THE COLONG FOUNDATION FOR WILDERNESS LTD.

Tuesday December 13th, 2016

Submission regarding Western Coal Services SSD 5579 Mod 1

Figure 3 – Overview of the Western Coal Services Project

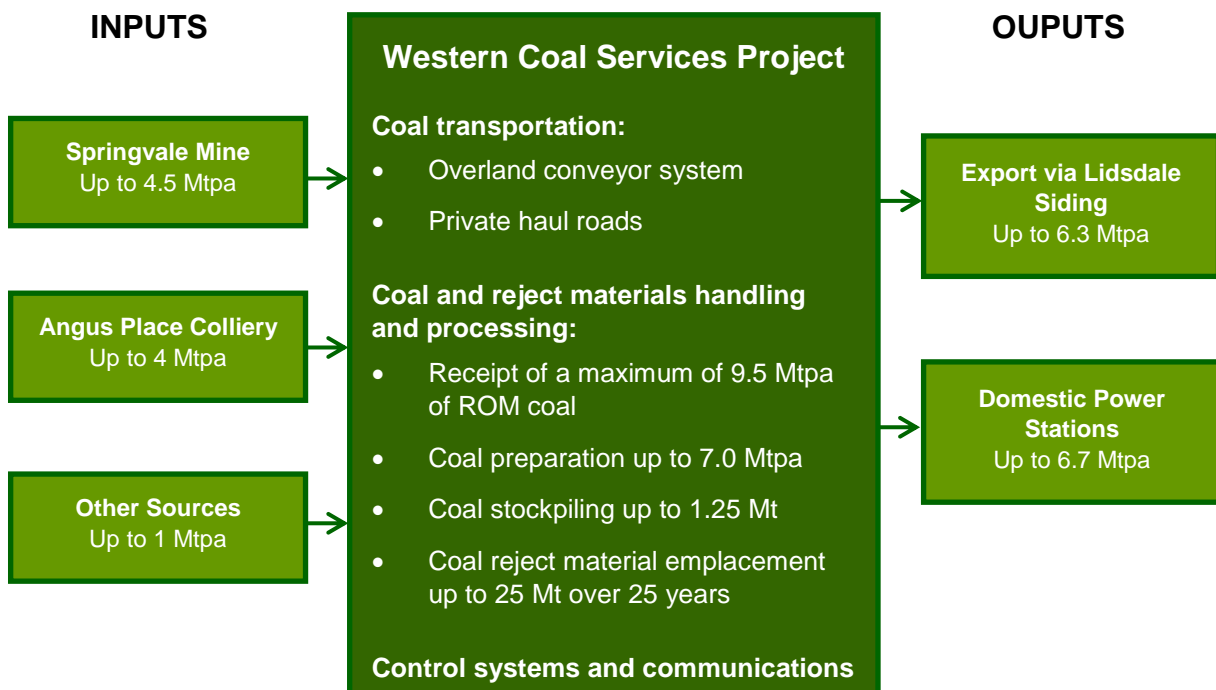
The modelling assessment admits that mine water from old underground mine workings will find its way to LPT006 through Cooks Dam to Wangcol Creek (see *Figure 3 modelling schematic*) but ignores the large non-point groundwater discharges from the project area (see *additional Figure A* at the end of this submission).

The lower part of the proposed “clean” catchment surrounds appears to be separated from the Co-disposal REA. This REA is described in the text on page 28 as having six cells. The two eastern cells are described as holding decant water, however *figure 3* shows decant water from these cells going to LDP006.

The regulation and treatment of contaminated groundwater within the project area is not investigated by the SEE. Ground water collection at Cooks Dam seems the most favourable option for its collection and subsequent treatment according to the schematic below (see *Figure 3*).

Figure 3 The water transfer schematic does not explain that the 'Groundwater Environment' receives large inputs from the extensive waste heaps in the project area, not just the REA but also the ash emplacement areas, and possibly metropolitan waste area.

**Figure 8 – Primary Rehabilitation Domains at the SCSS
(Adapted from RPS (2013a))**

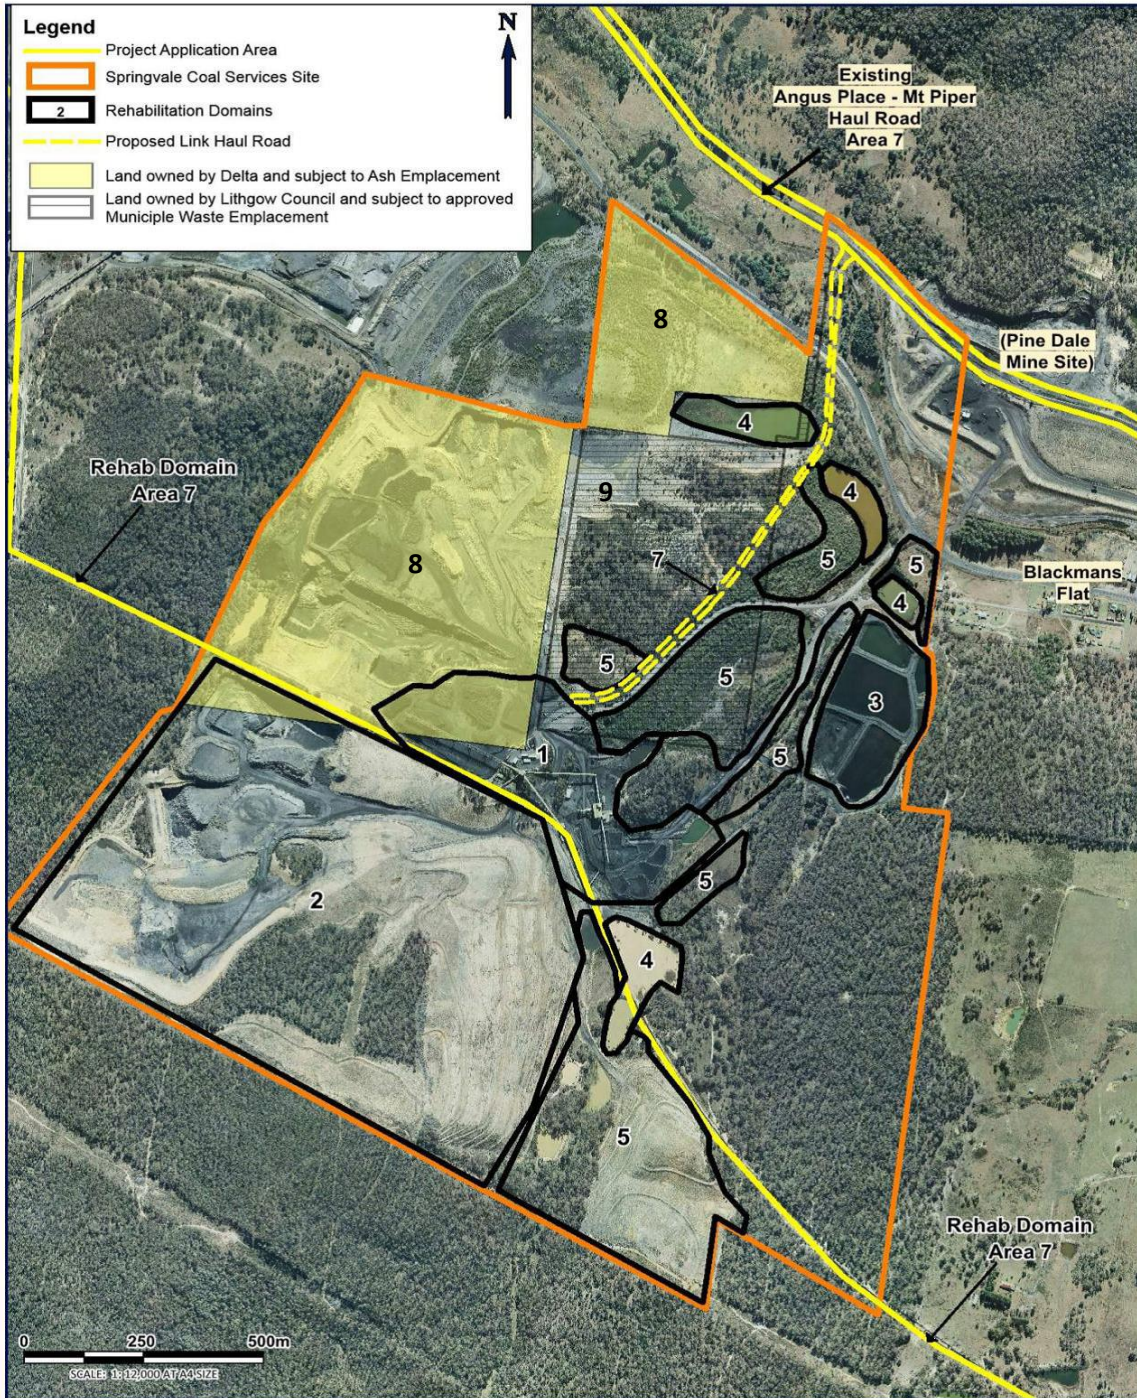
Municipal waste dump development also will replace a large part of the “Lamberts Gully Rehabilitation offset areas” (see *additional figure D*). Loss of this offset appears not to be accommodated by further offsets, and is a poor practise, as ecosystems can’t be traded as commodities without unexpected ecological outcomes.
